Application Ref: H02-0017-26

Proposal: **Erection of 2 dwellings with associated parking**

Location: **Rear of 92 - 94 North Street, Crowland, Peterborough PE6 0EF**

#### ADDITIONAL INFORMATION REQUIRED

<b>title</b> <b>PROPOSED SITE PLAN</b>	<b>scale</b> <b>1:250 @ A3</b>	<b>date</b> <b>JUNE 2025</b>
<b>contract</b> <b>UK EQUITY LTD.</b>	<b>revision</b> A 18/06/2025 DRAWING ISSUED B 12/12/2025 REVISED FOR PLANNING C 08/01/2026 RAMP ADDED

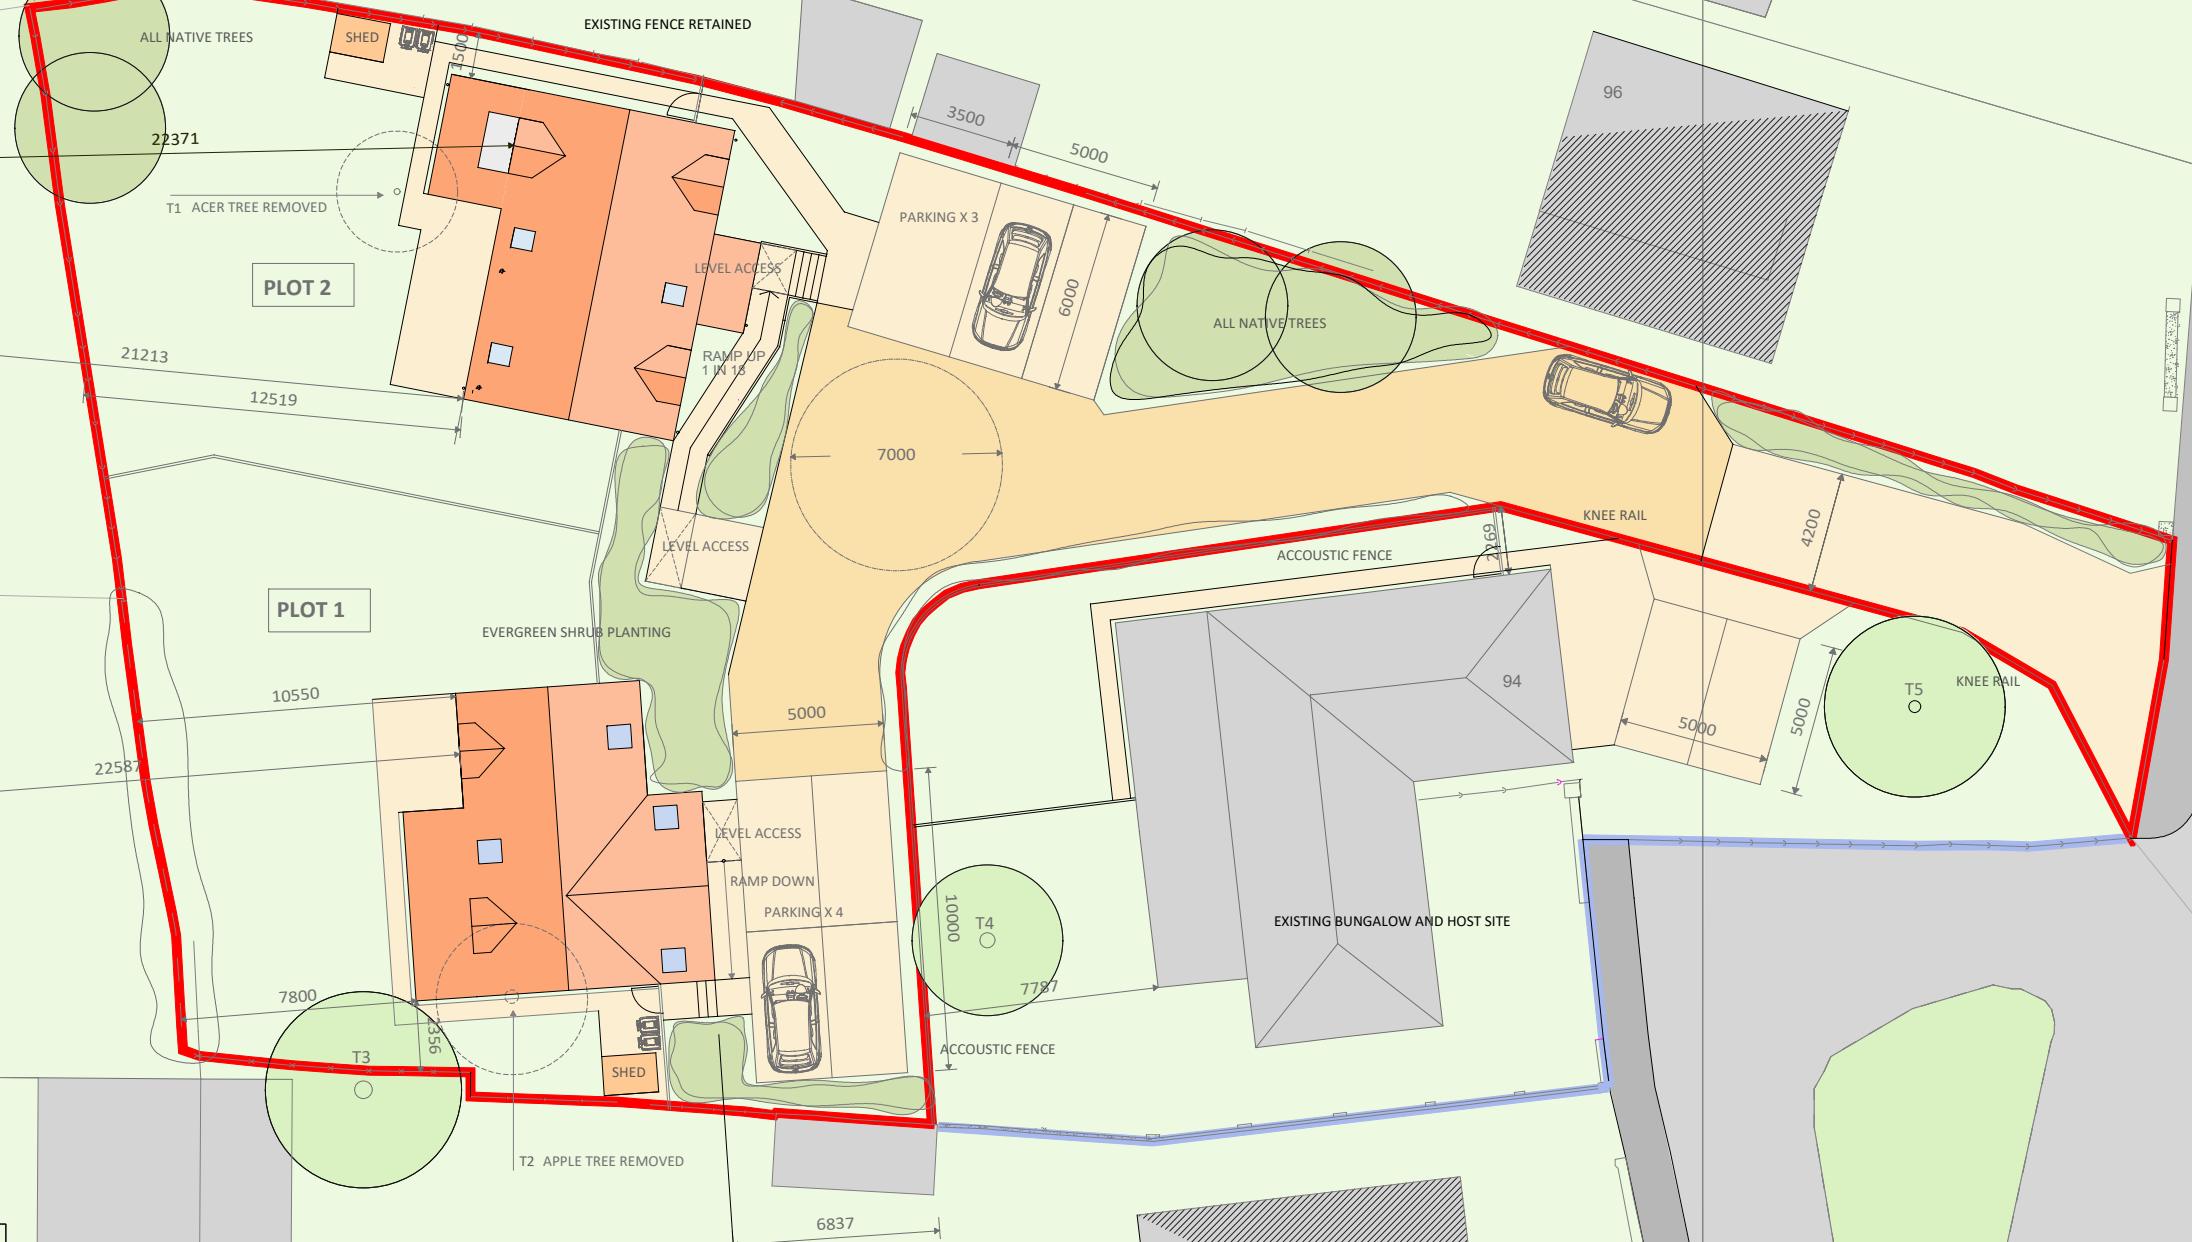
How many bedrooms does the host dwelling (96) have? I need to ascertain if two parking spaces are sufficient.

A note is to be added to the site plan to say the access will be upgraded to Lincolnshire County Council Specification.
